Great North Road Solar and Biodiversity Park

Final Statement of Common Ground with Nottinghamshire Wildlife Trust

Document Reference – EN010162/APP/8.11C

April 2026

FIGURE 5.2 (1)

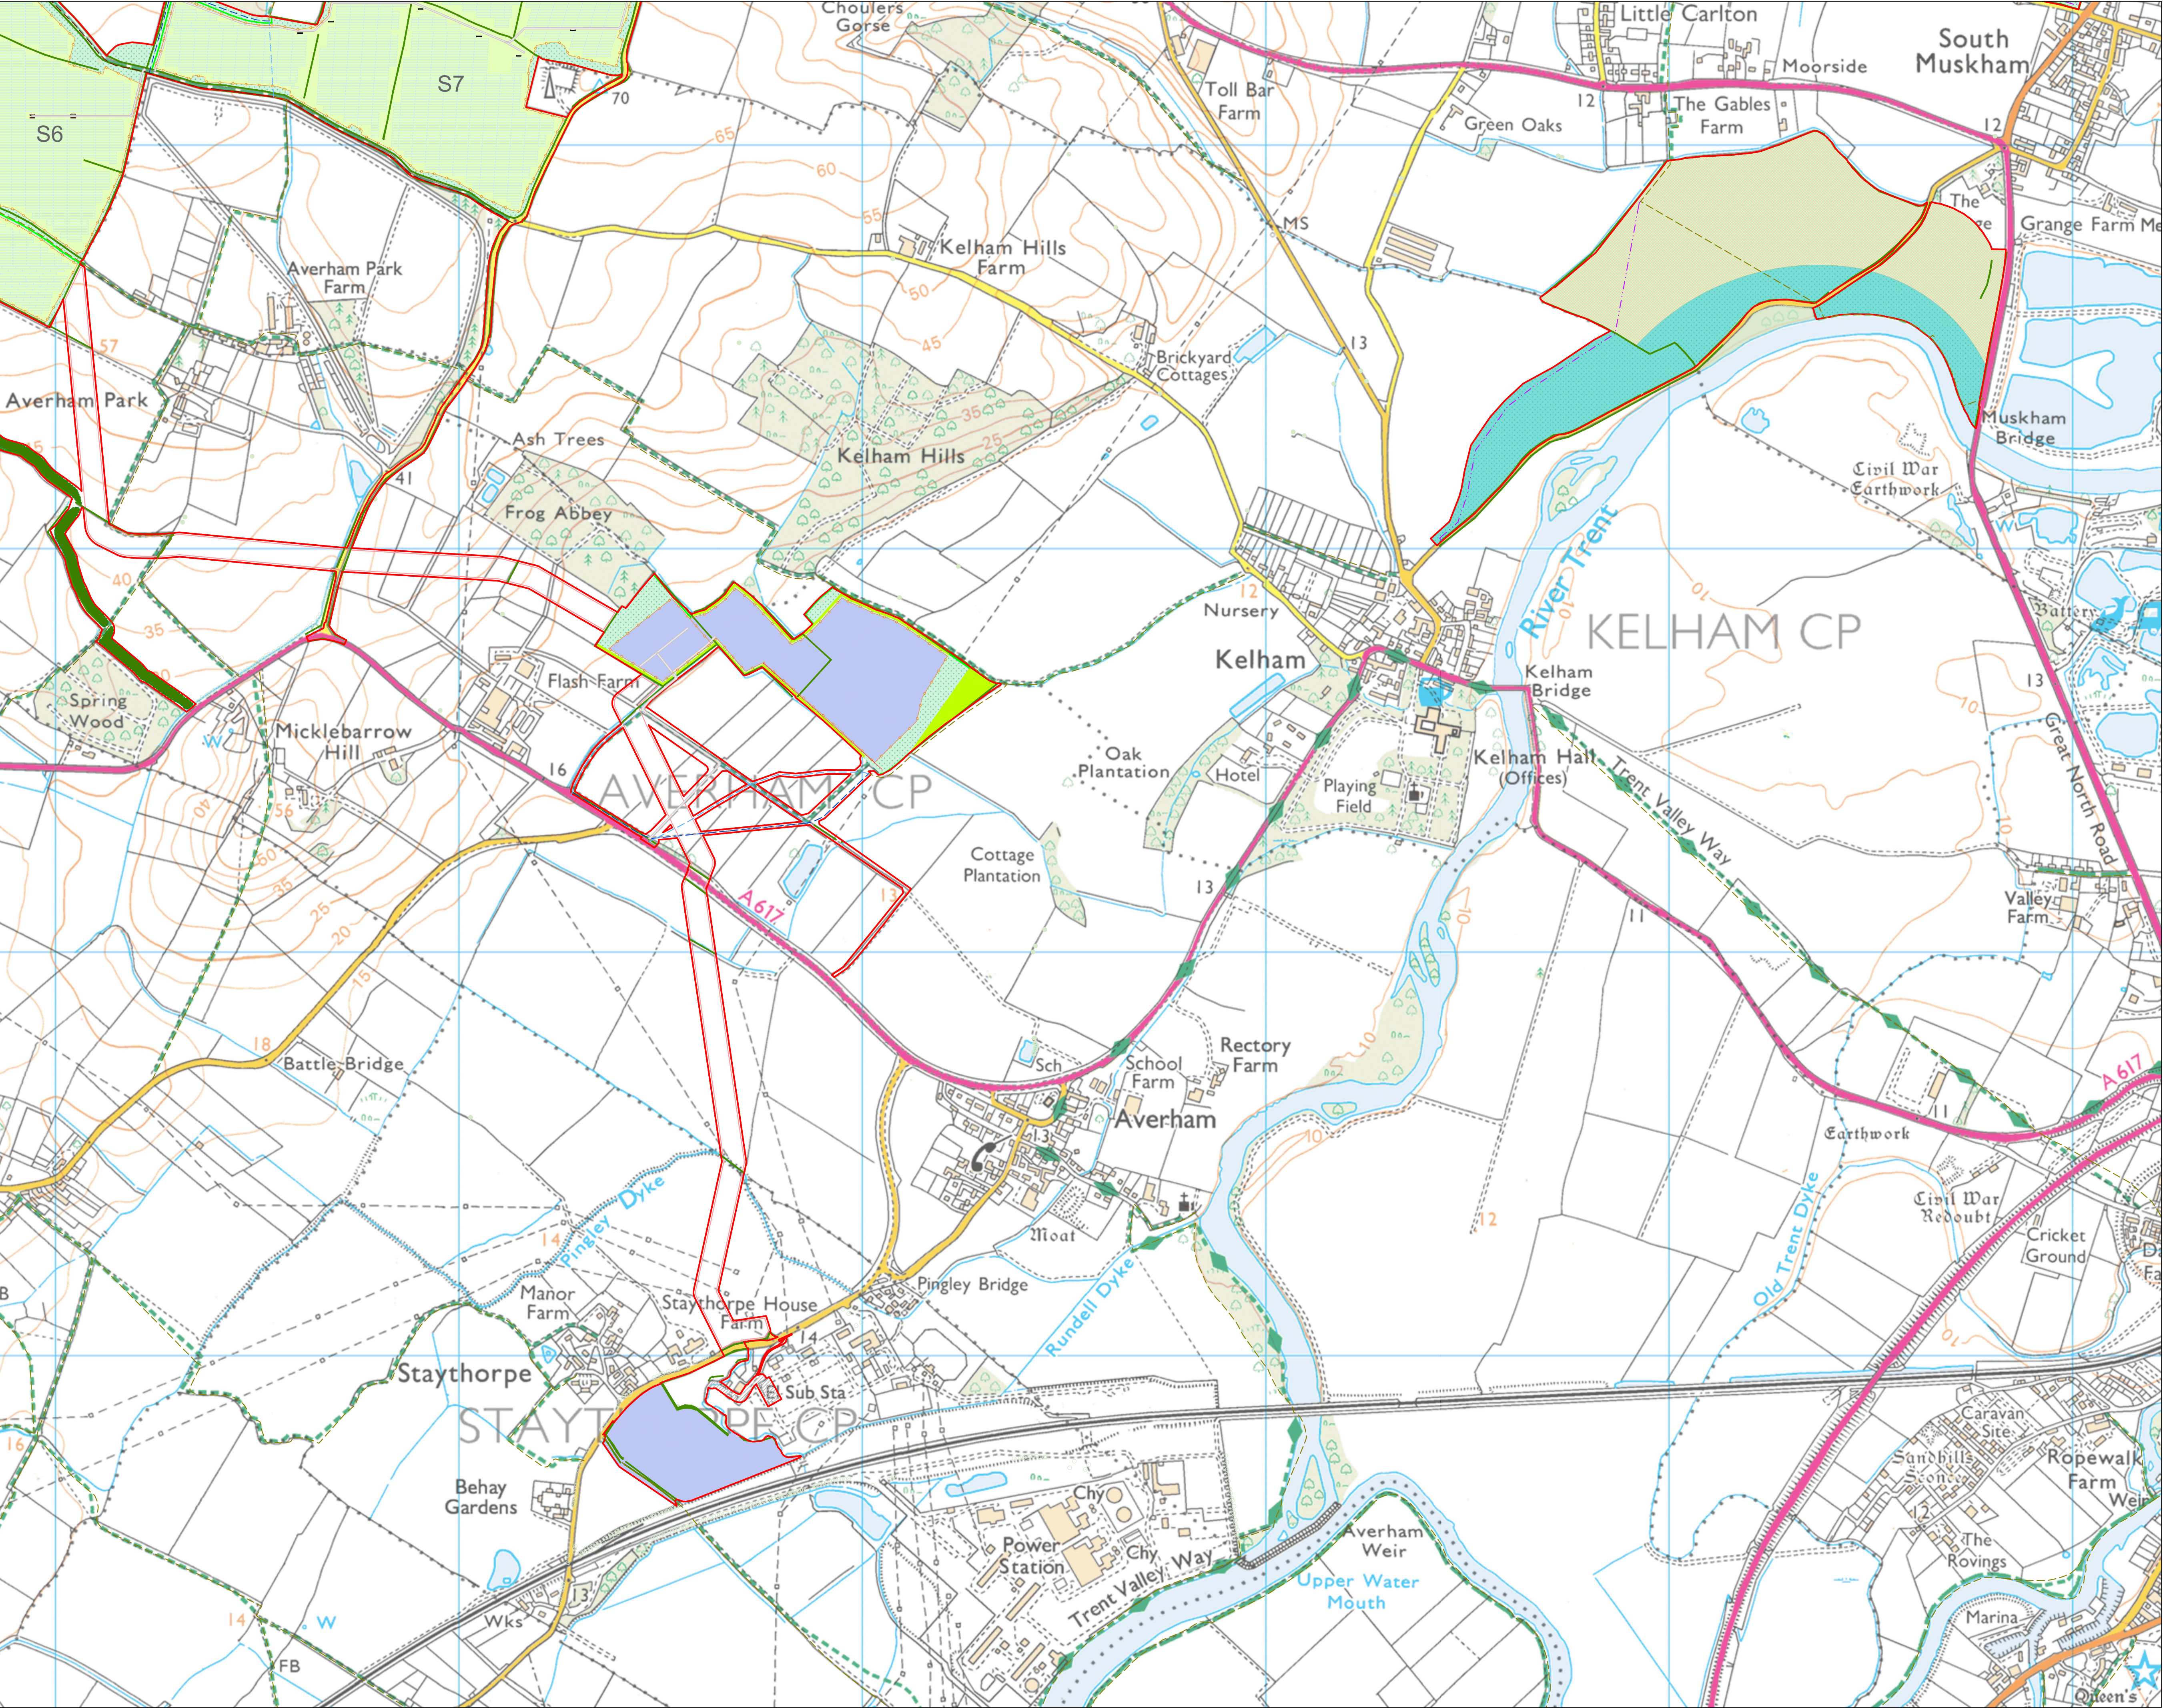
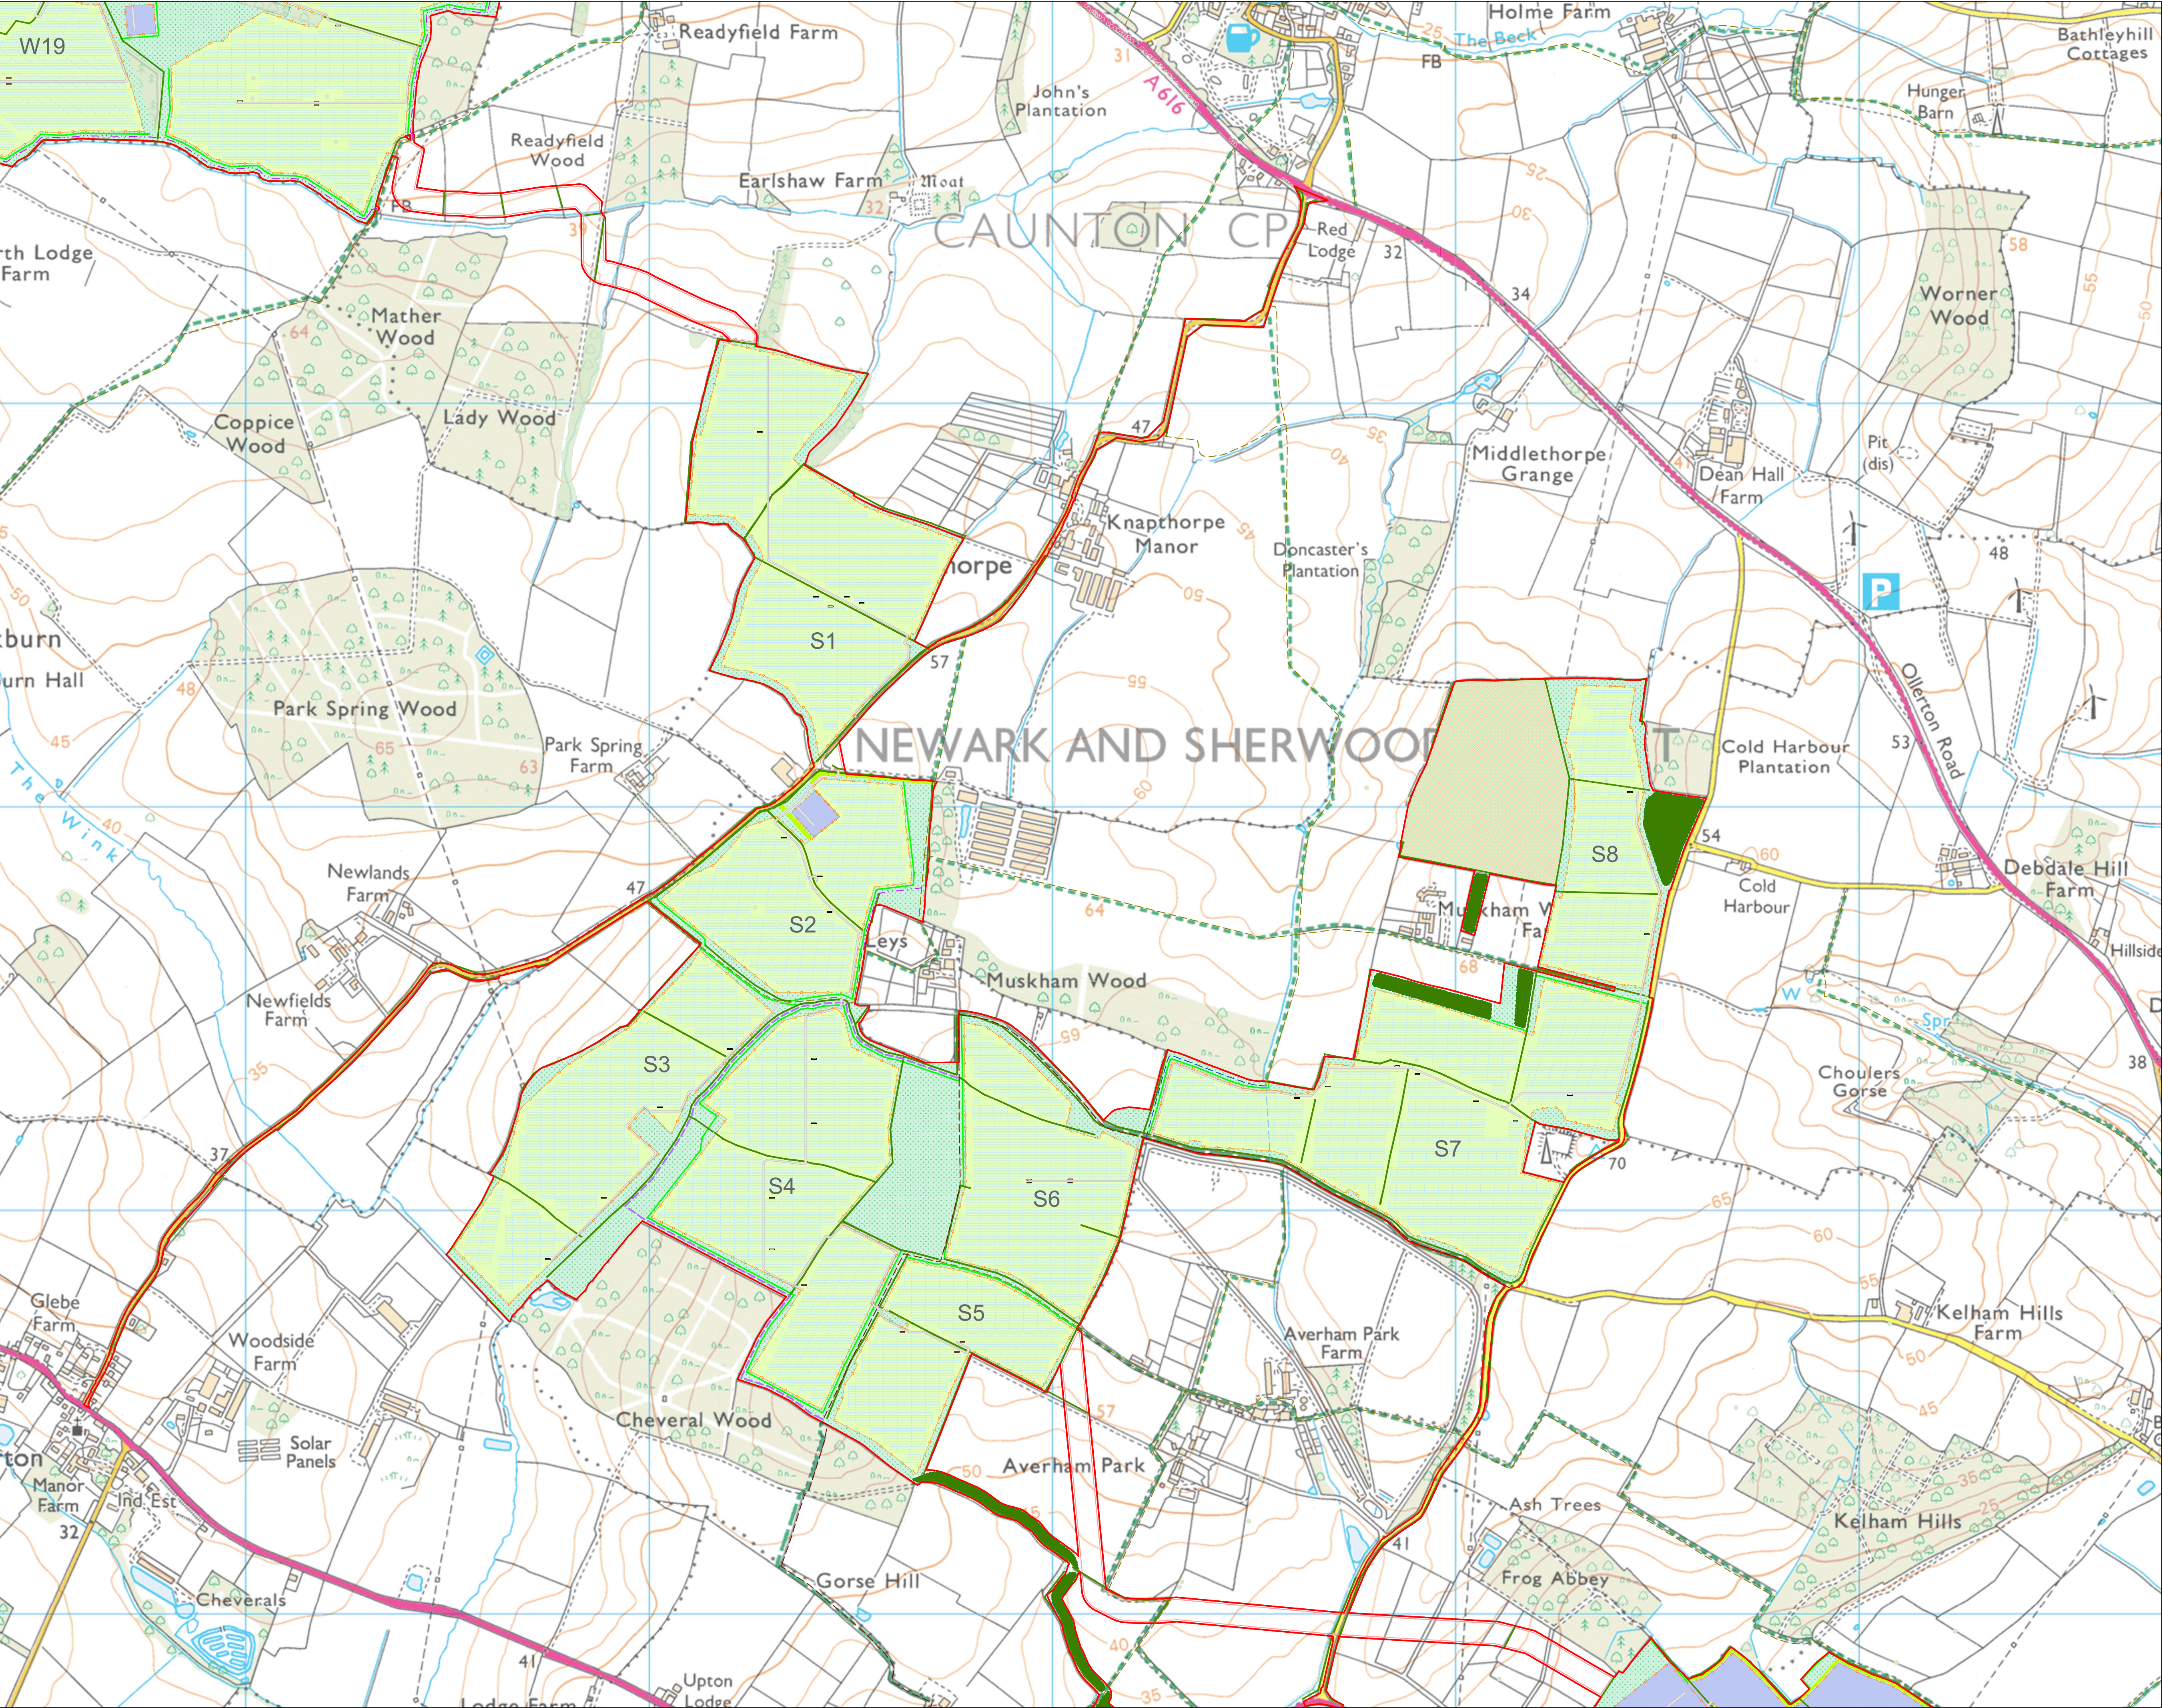
2.2.9	Meeting (27/01/2026)	Scattered tree planting	Concerned that tree planting in or near open areas would discourage nesting birds such as lapwing and waders. Recommend that black poplar is included in the tree planting specification.	The specification of the tree planting in the riparian corridor has been revised in section 22 of Table A5.1.5 in ES Volume 4, Appendix A5.1: Outline LEMP [EN010162/APP/6.4.5.1C] [REP3-032] to make clear that the locations of tree planting will be selected to limit their potential to discourage nesting birds. The locations shown on the Masterplan are therefore purely indicative. Black poplar has been added to the specification.	Agreed
